415 Cumberland Avenue

415 Cumberland Avenue - Final Traffic Comments

Subject: Application ID: 2018-011

PEZ 2018-011: Building Conversion, 415 Cumberland Avenue

ELEVATIONS

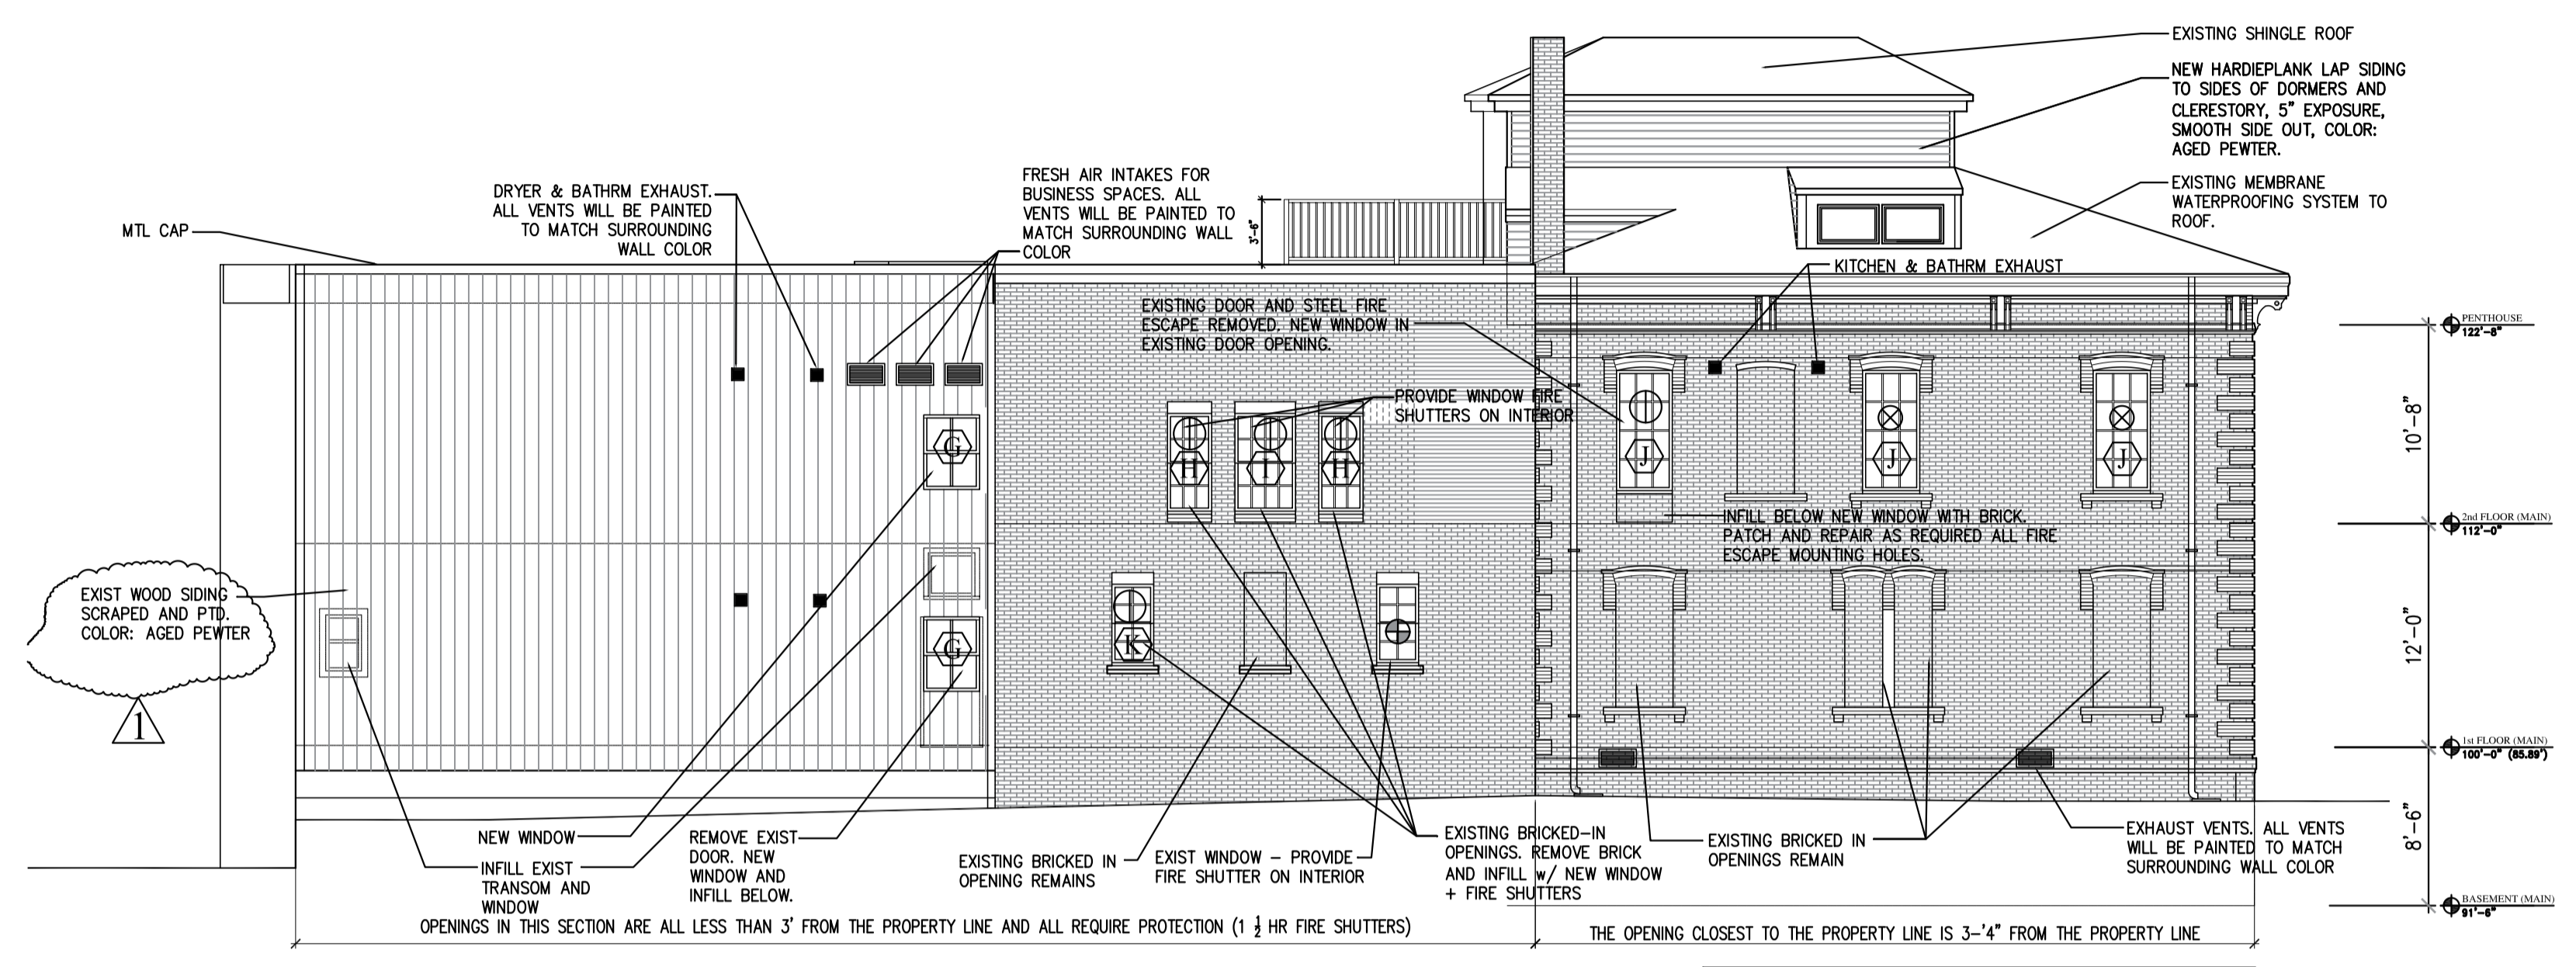
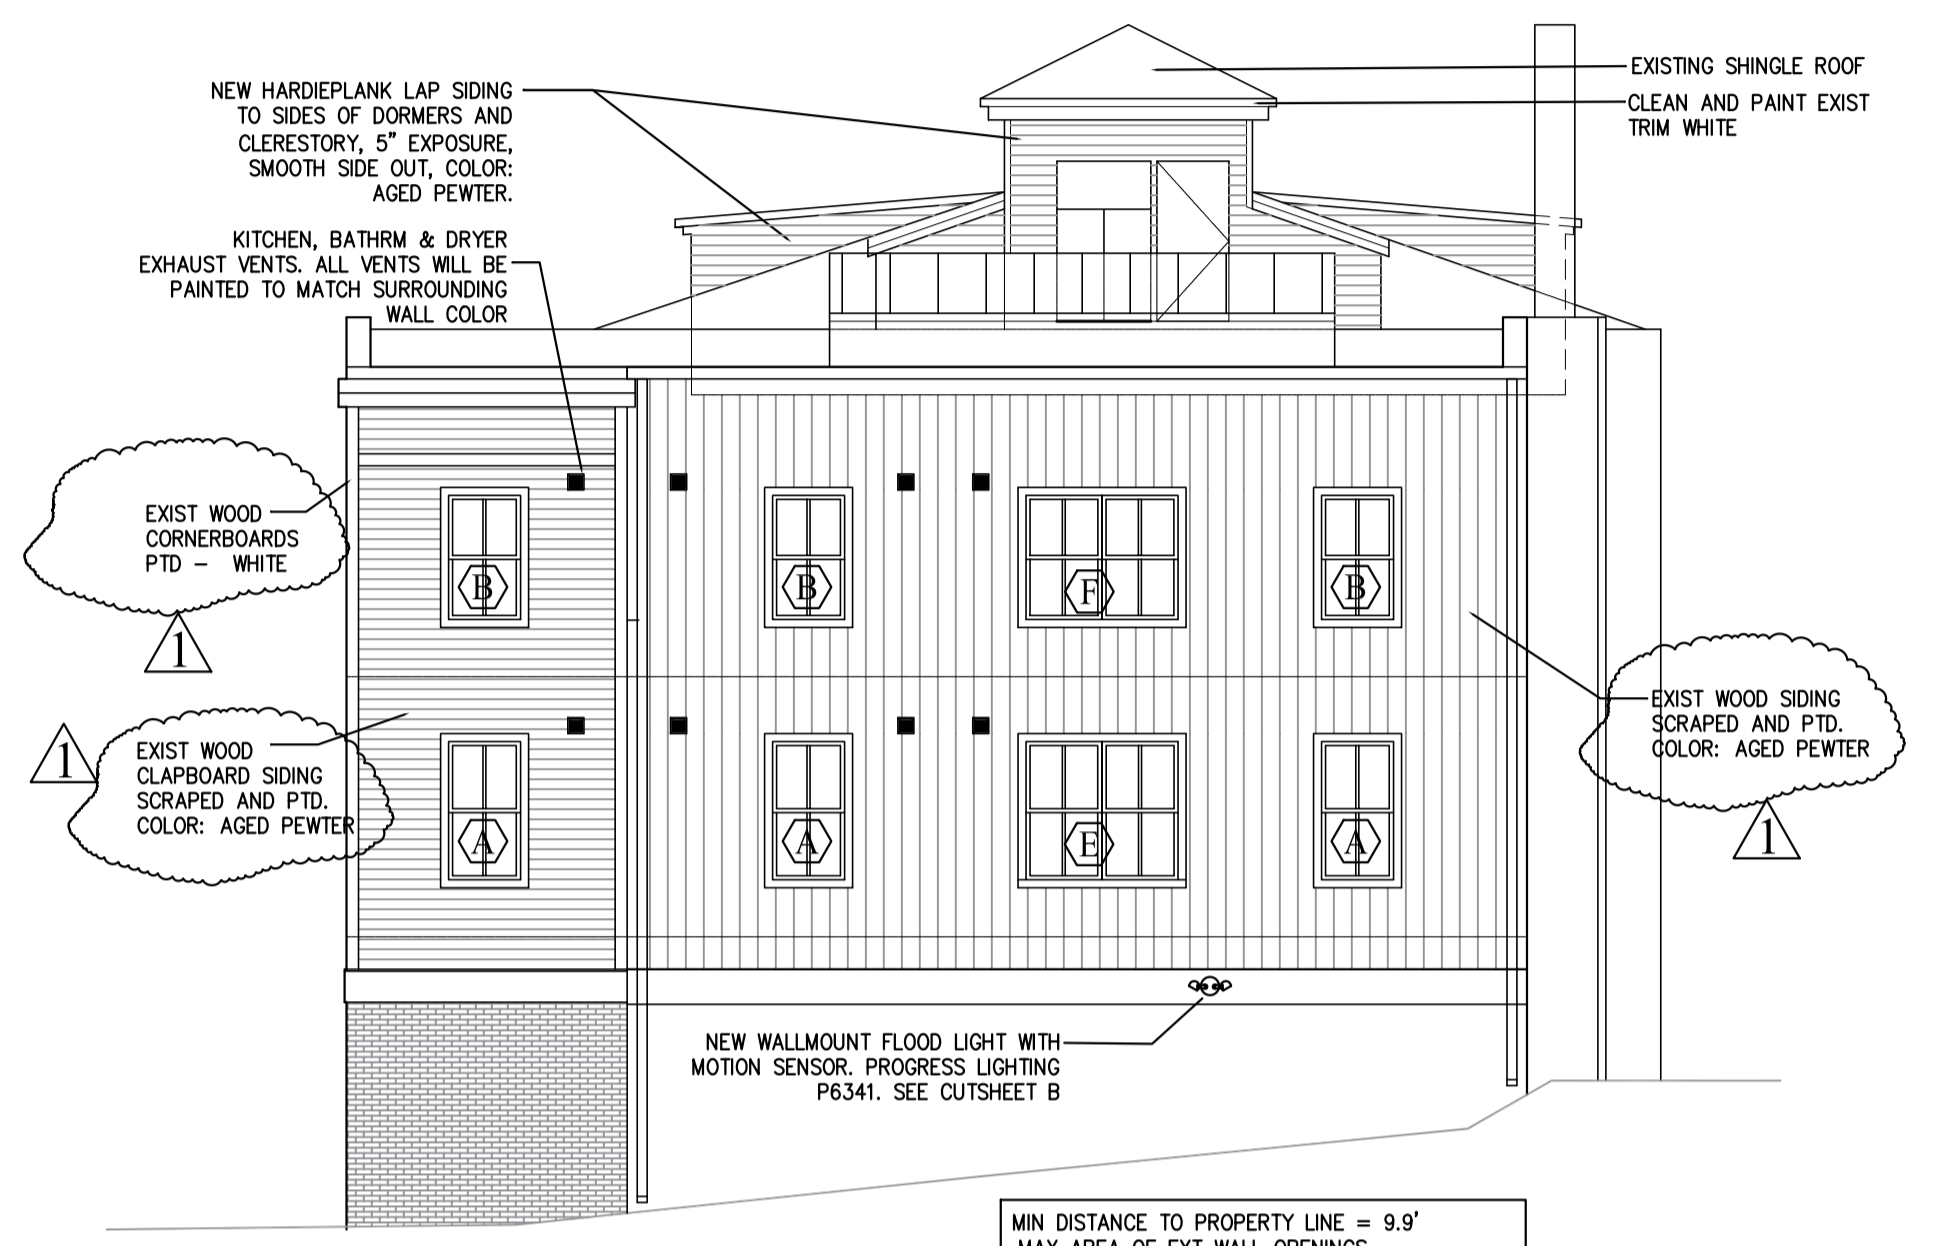
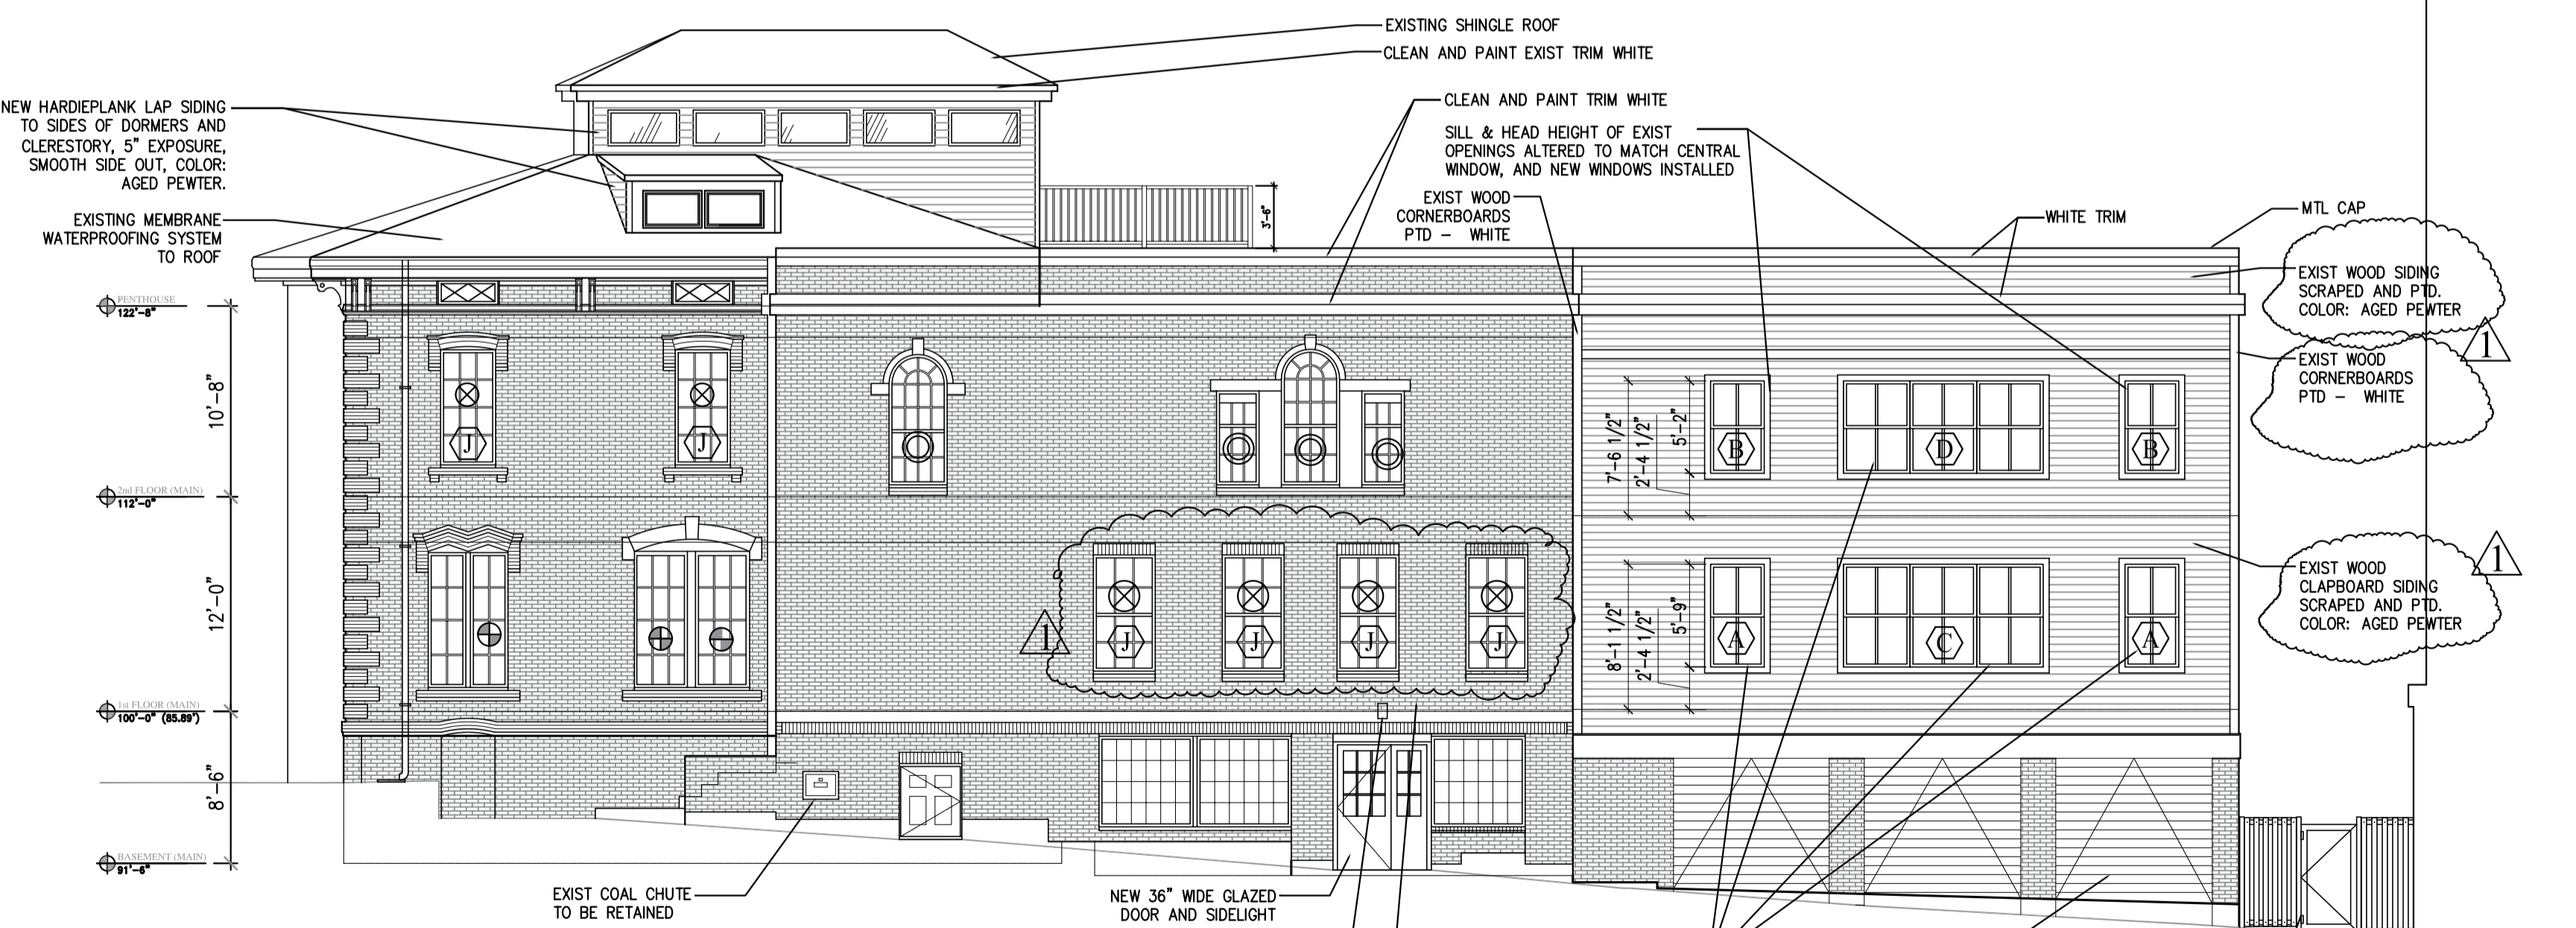
Request details on new windows. What are the materials? Windows should feature simulated divided lites with applied exterior muntins, at a minimum. Also, which windows will be repaired/replaced?

Request details regarding window moldings: will brick moldings be replicated in aluminum trim on other, new windows?

Why are two windows on the northwest elevation not the same height as all other windows on the northwest elevation and Forest Avenue elevation? Ideally these will match.

Request clarity / detail regarding the penthouse / mezzanine. What changes are being made, if any, and what materials are being used. Are the proportions of the existing windows changing?

Request details regarding finishes. Painted finish of Hardie plank should not be high contrast, nor should relationship of trim to body of building be high contrast.

What is reveal / ttw of Hardie plank? (Reveal should be less than 6.”)

Hardie plank should be installed smooth side out (please note on plans).

Exhaust vents should be painted to match surrounding material (brick or Hardie plank siding).

Hardie plank at top of building parapets on Forest Avenue and southwest elevations seem strange – the treatments / bands along the top of the building’s middle section should be continued.

Will garage doors be replaced? If so, materials / details requested.

Request details regarding proposed new door on Forest Avenue, especially regarding material and panelization.

Coal chute should be retained, not removed or covered.
